Re: Residential Development Copper Condos
3812-3816-3820 Copper Ave. NW
Traffic Circulation Layout
Architect's Stamp dated 09-19-18 (K17-D111)

PROJECT: 1523 Copper 4 Plex

This TCL Resubmittal documents the Design Change to delete the construction of parallel parking on the south side of Copper Ave NE along this project's street frontage.

PARKING ANALYSIS - TRAFFIC CIRCULATION PLAN

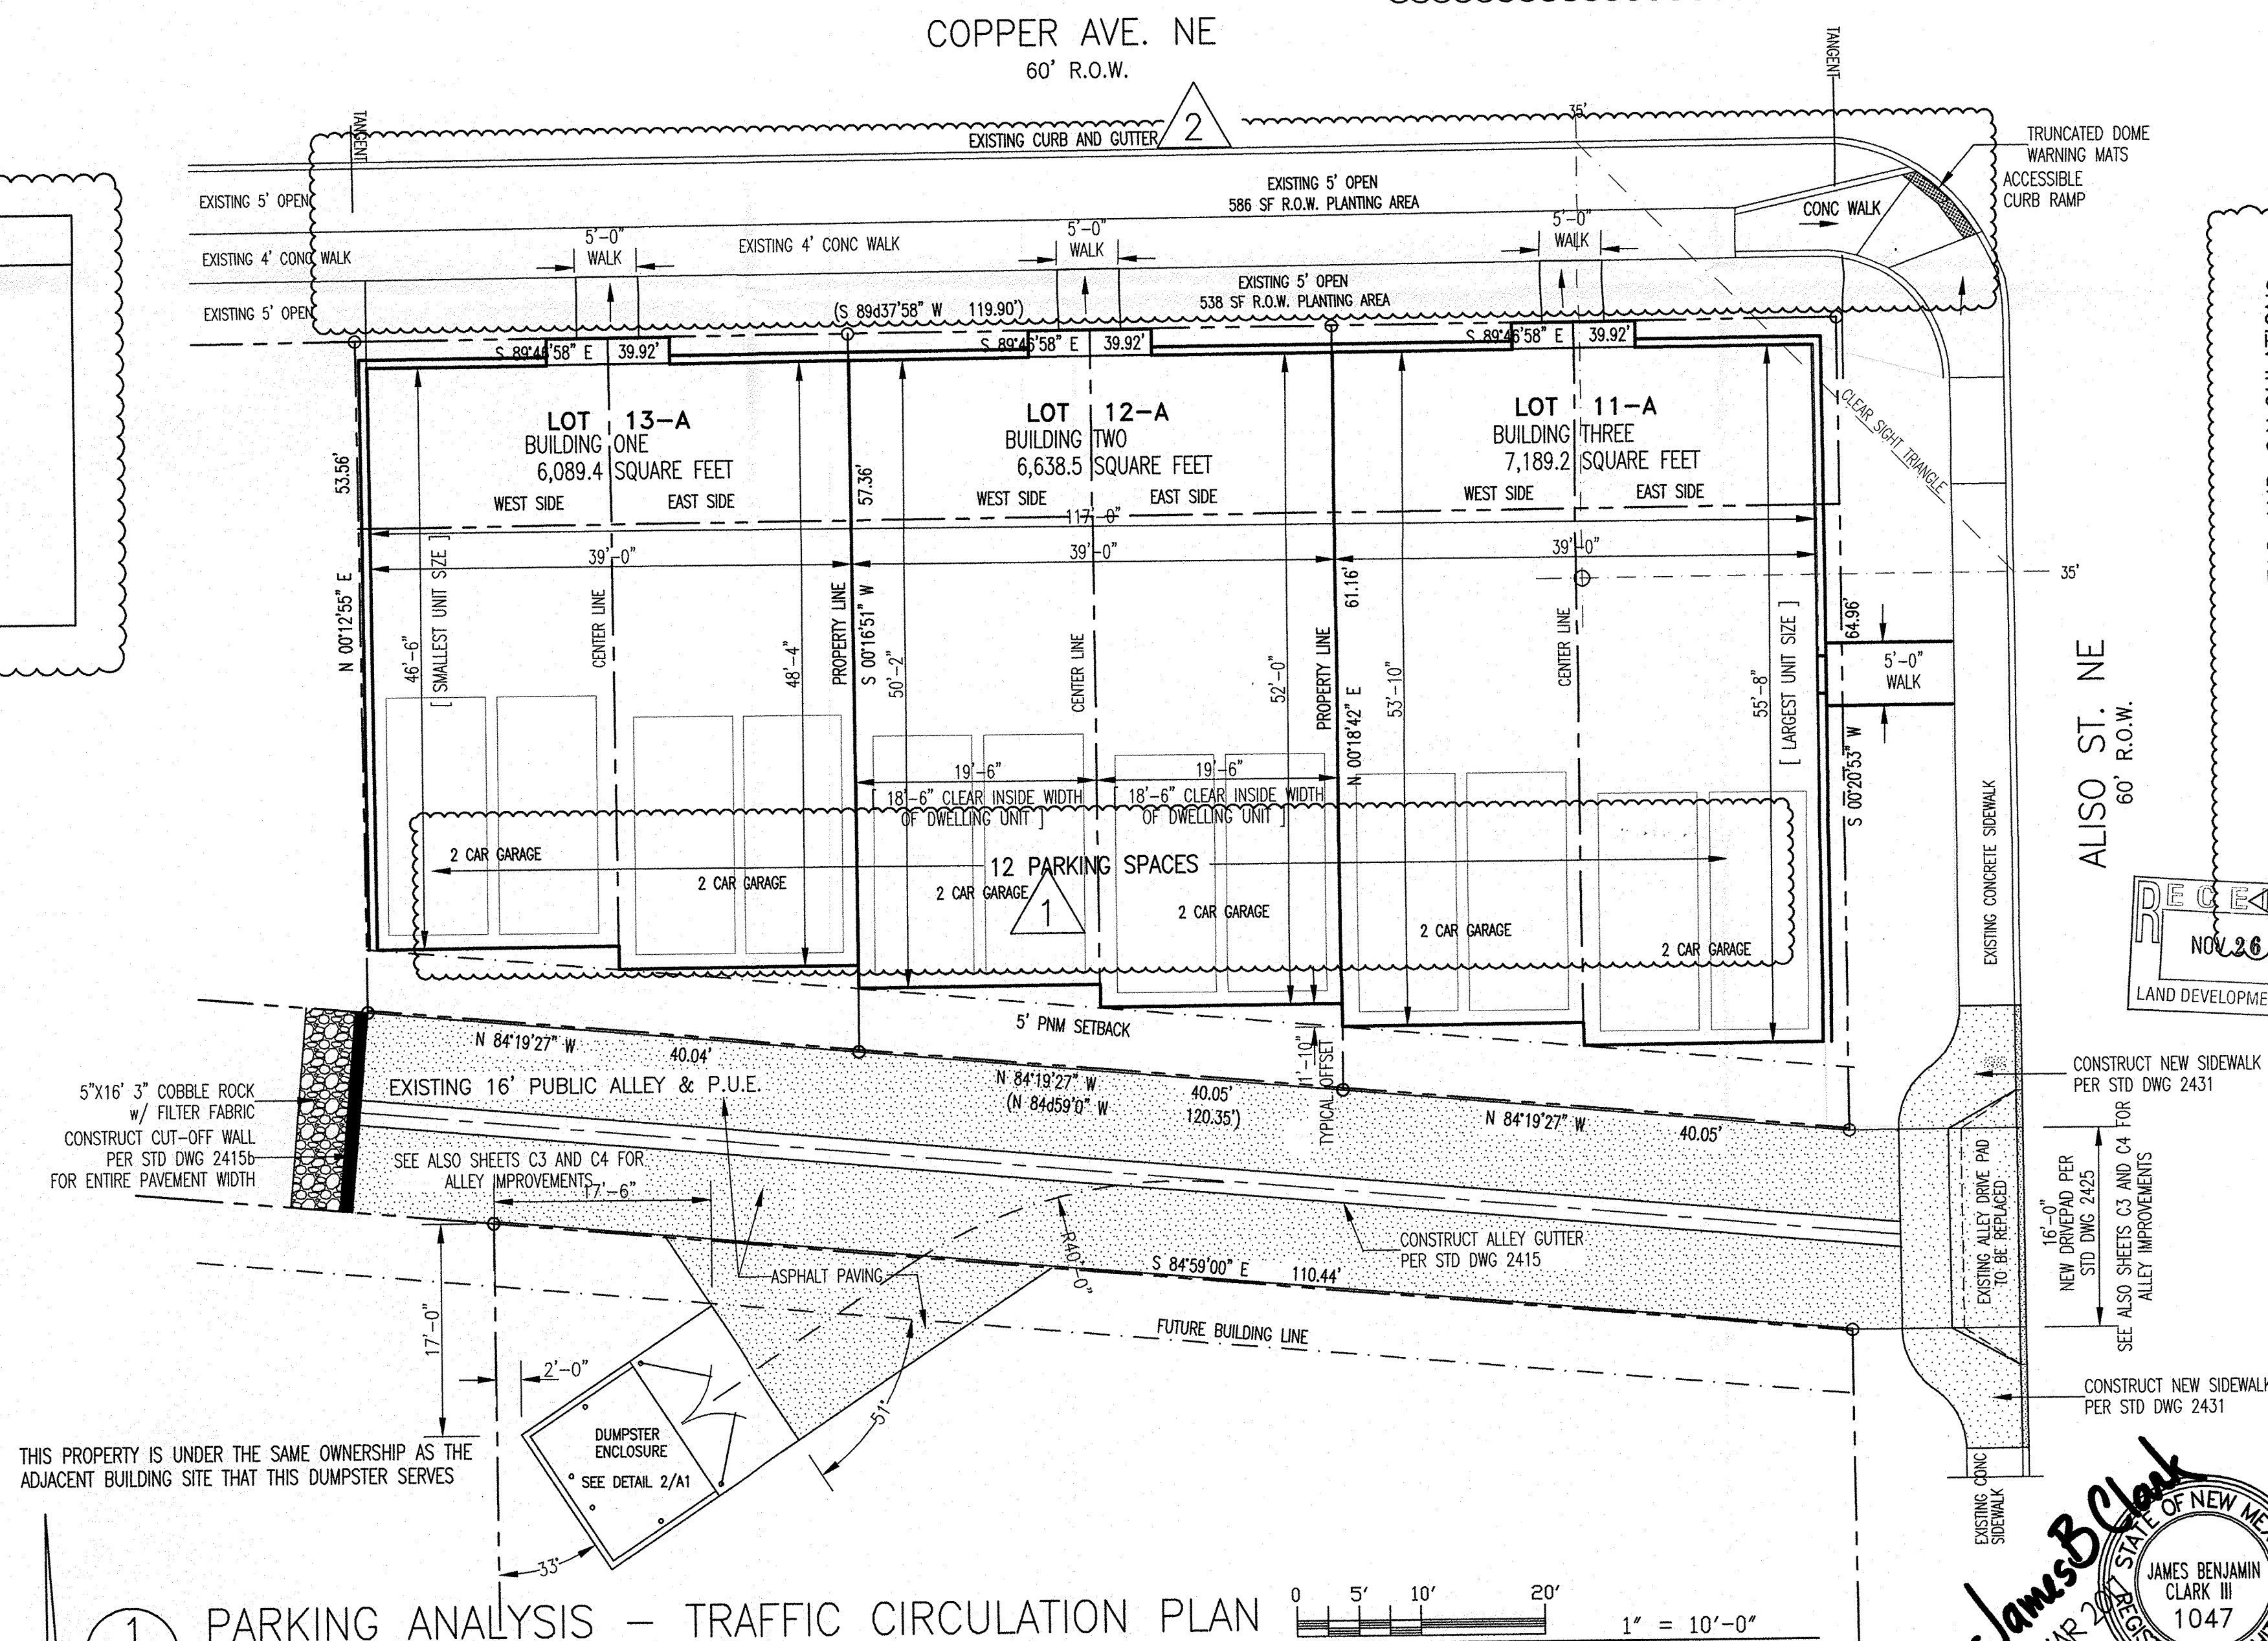
All other aspects of the previously approved TCL Plan dated 3/8/17 are unchanged.
